CITY OF PORTLAND, MAINE

PLANNING BOARD

March 17, 2015

Project Name: Midtown
Project ID: #2014-203
Address: 59 Somerset Street
CBL: 34-B-2, 3, 4, 5, 22 and 34-D-3, 9, 10
Applicant: FEDEQ DV001, LLC.
Planner: Richard Knowland

Drawing file: FST - Site Plans Revised 01-21-2015 / C-7.12 Bayside Trail Retaining Wall Retaining Details and Abuter Options.pdf

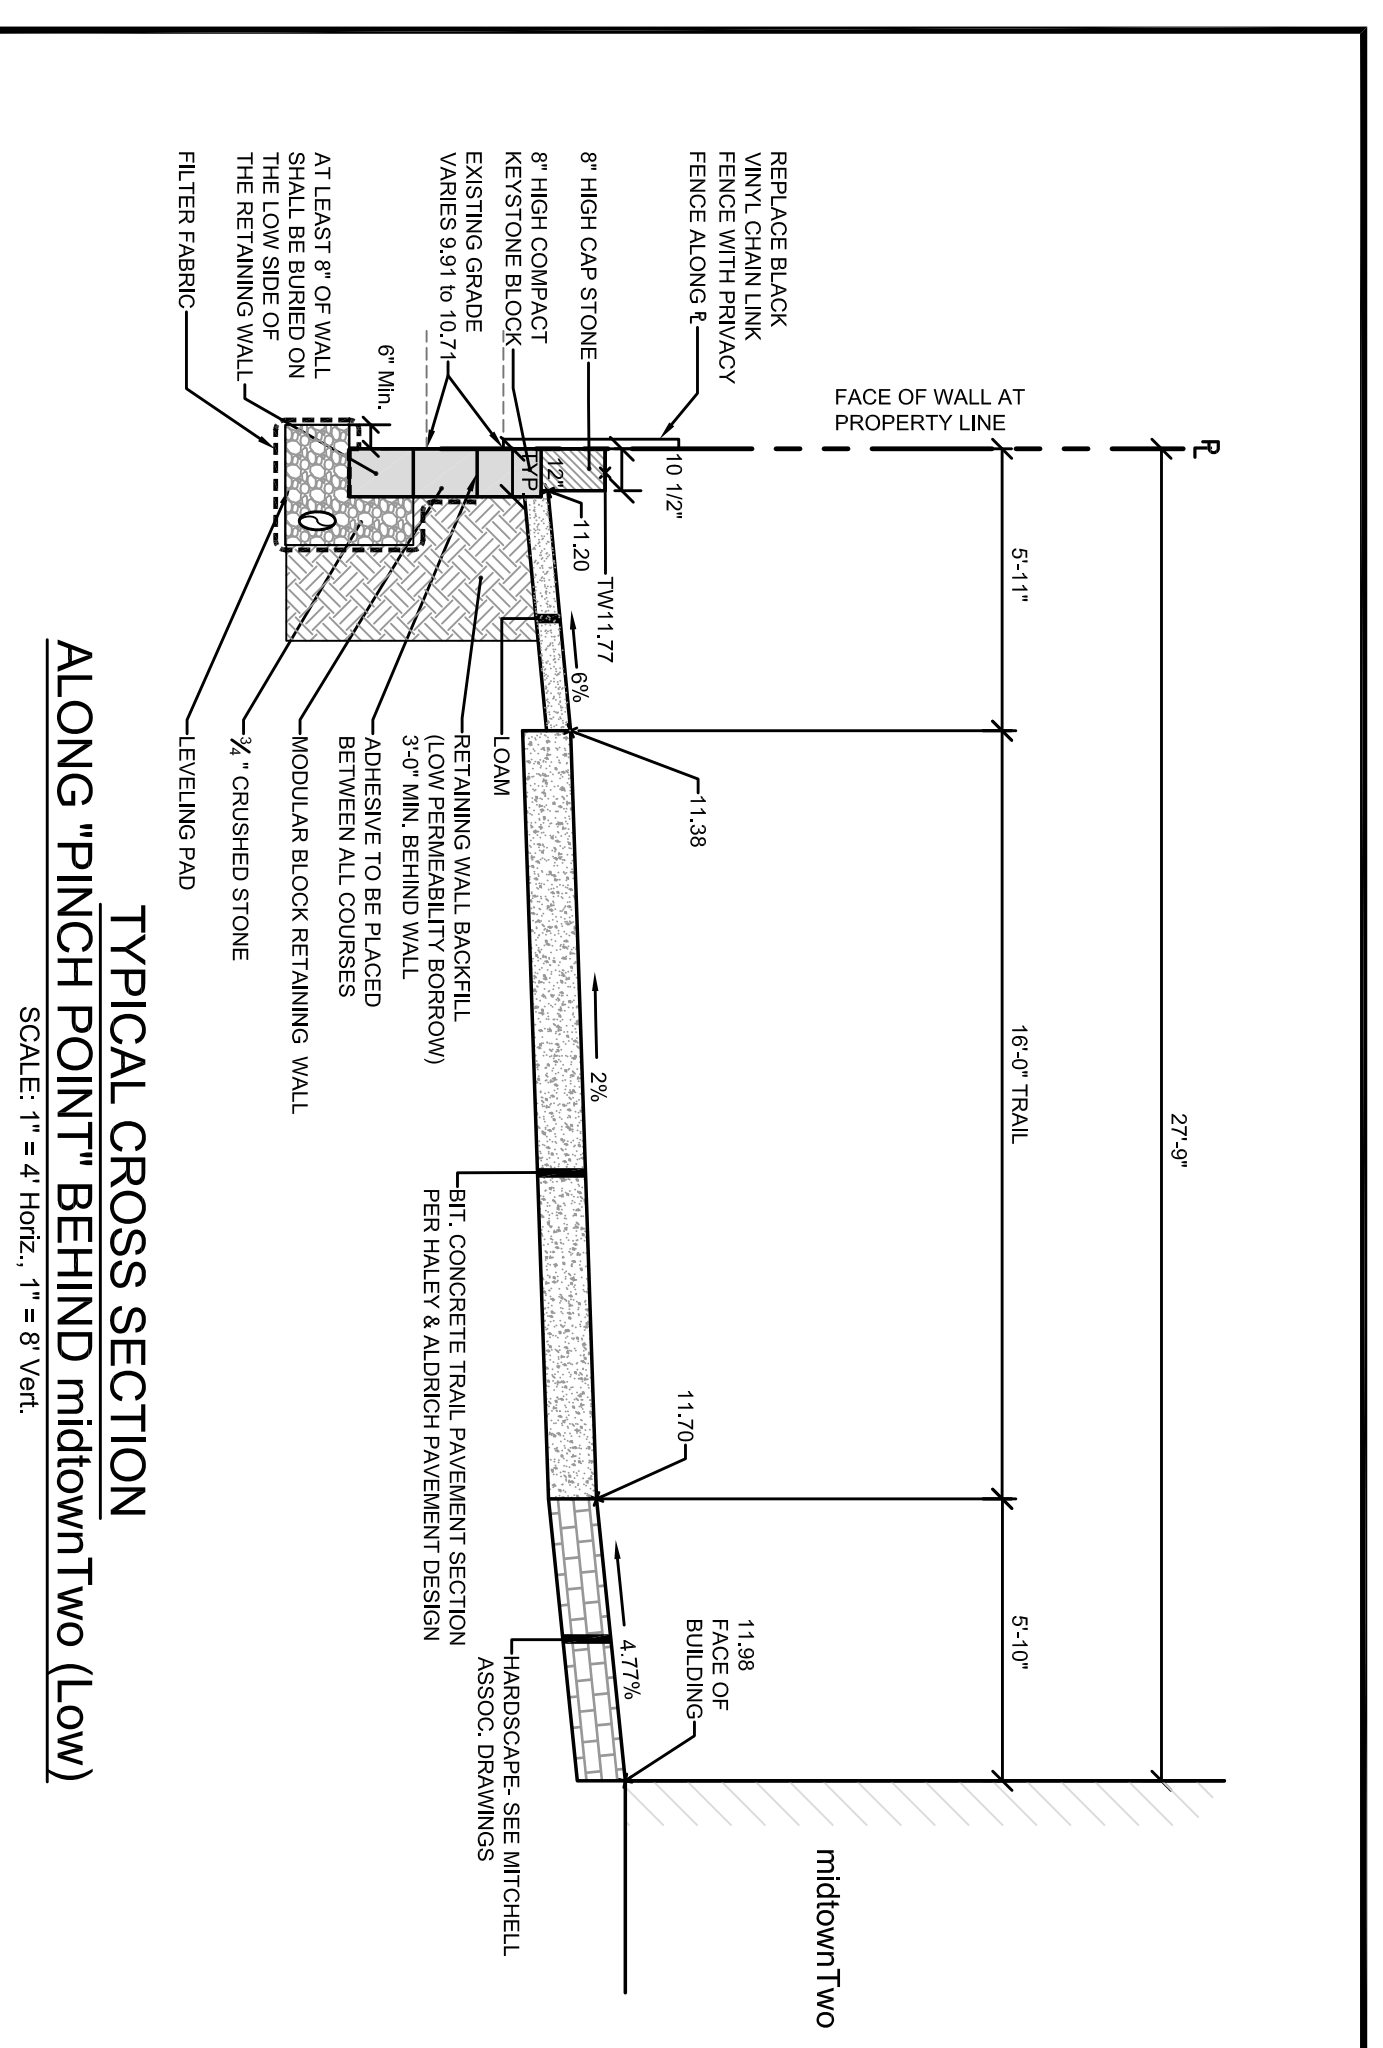
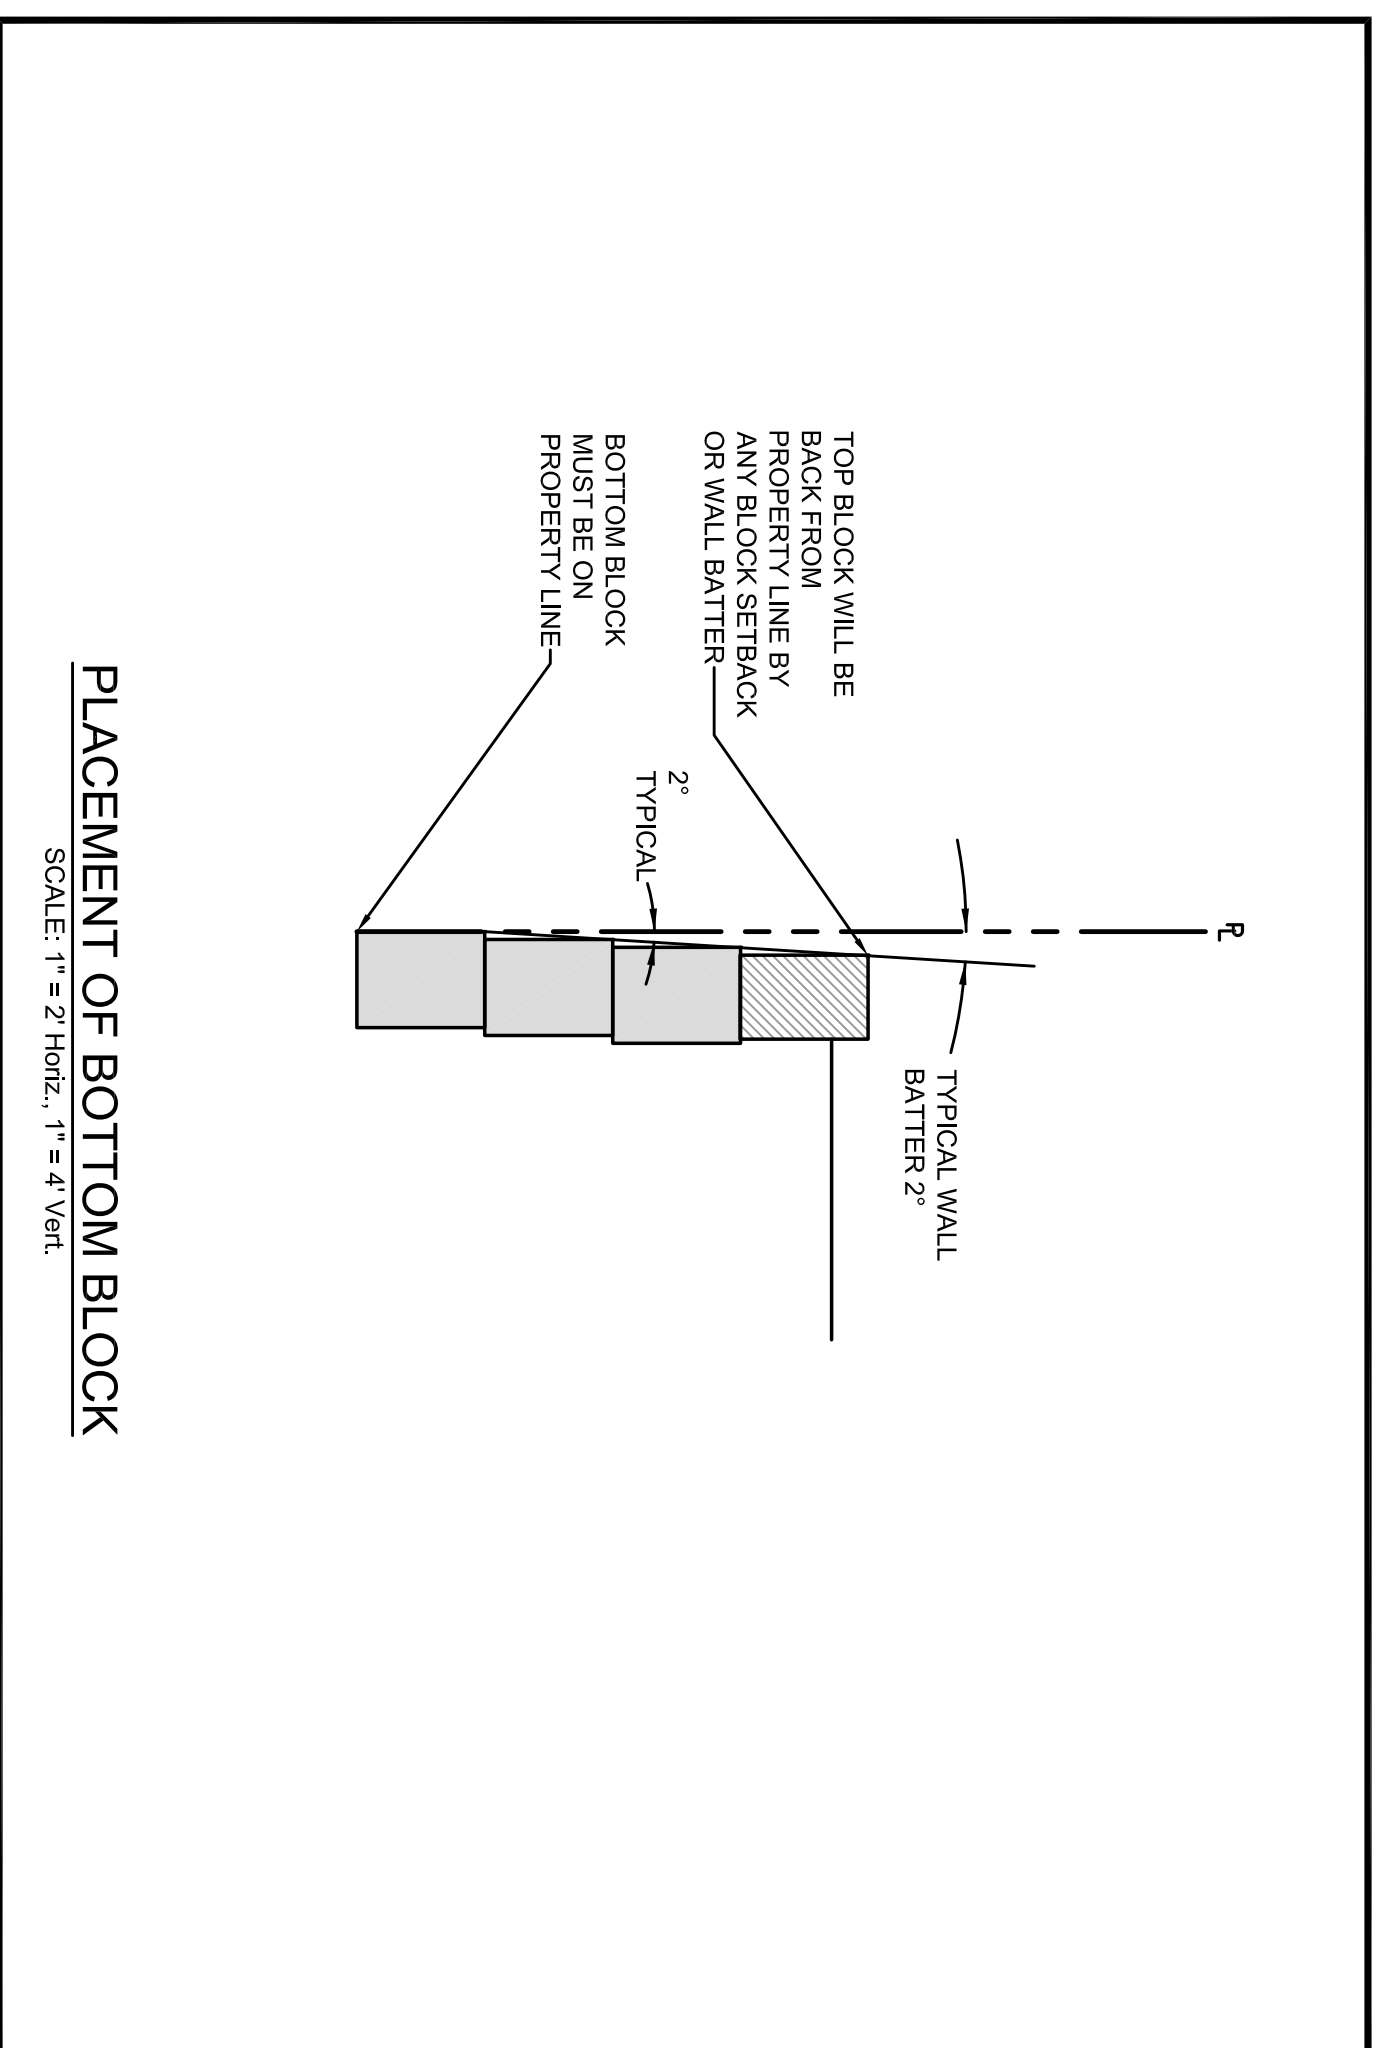
12. For the areas behind midtown One and midtown Two, from Bayside Trail STA 6+50 to STA 12+50 (refer to sheets C-3.0 and C-7.12), the face of the retaining wall and fence are proposed primarily on the property line between City of Portland (Bayside Trail) property and the parcels located north of the Bayside Trail. Temporary construction agreements shall be obtained by the Applicant from the adjacent property owner(s) to complete the work as proposed.
